REPORT on the IMPLICATIONS for EUROPEAN SITES

Proposed A46 Newark Bypass

Planning Inspectorate Reference: TR010065

14 January 2025

Figure 2 Option 4 indicative locations of fish escape passages from Farndon flood compensation areas into Old Trent Dyke.

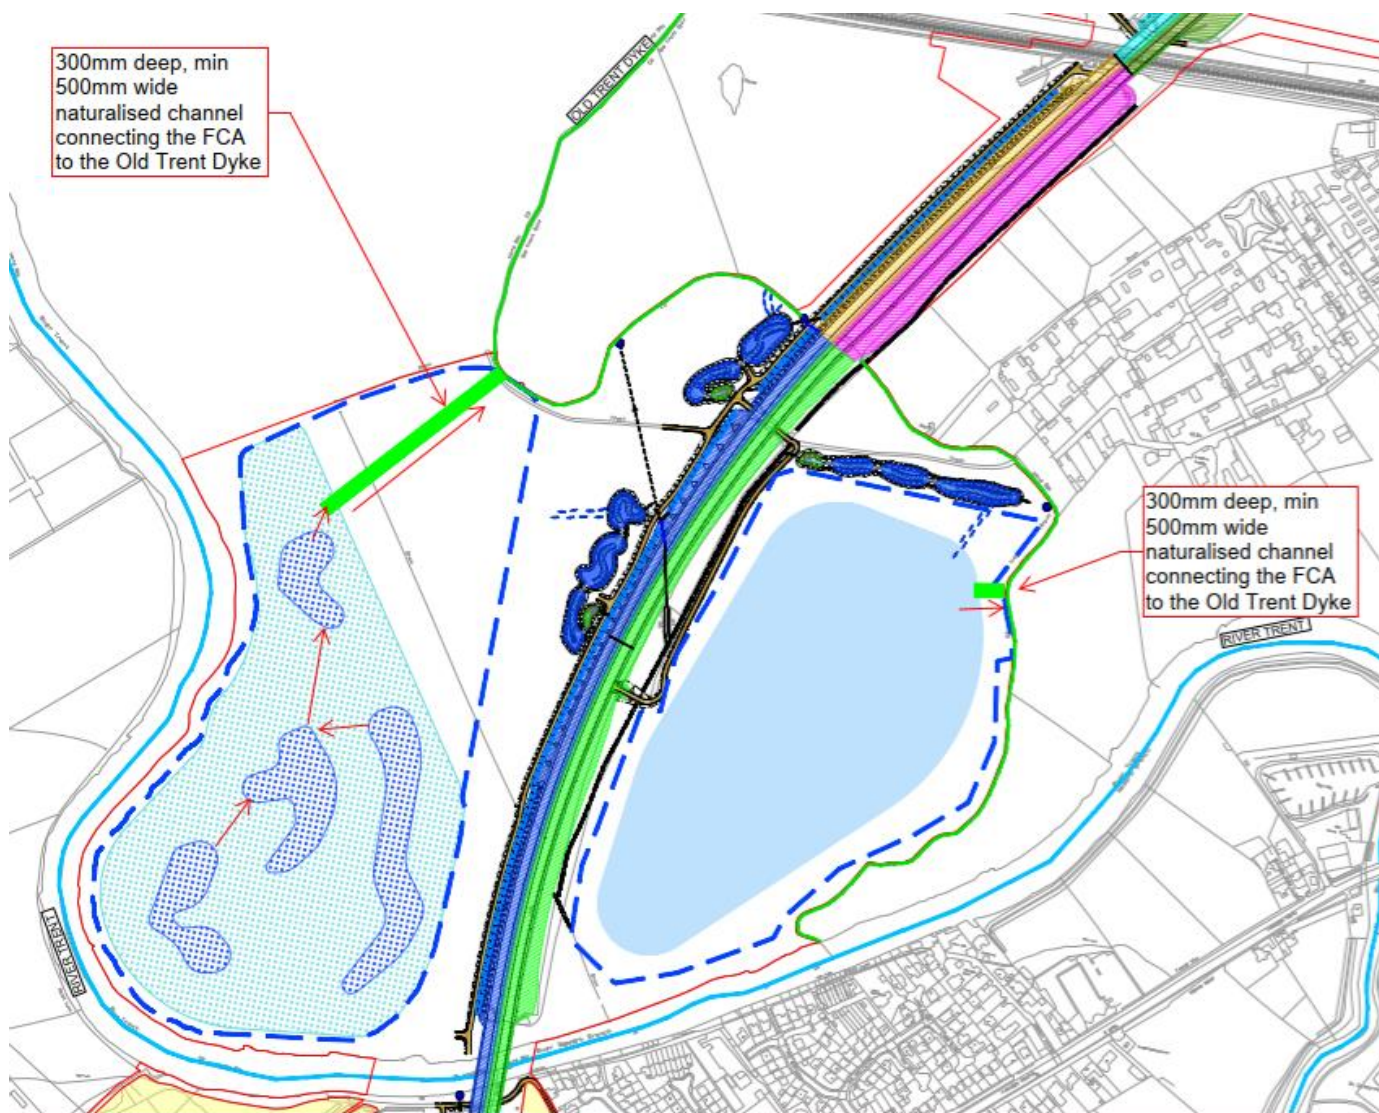
3.5	Operation	<p>The EA [REP3-044] requested that the applicant provide details on maintenance of the Farndon FCAs fish escape passages.</p>	<p><u>QR8 – Are the EA satisfied with the maintenance measures</u></p>
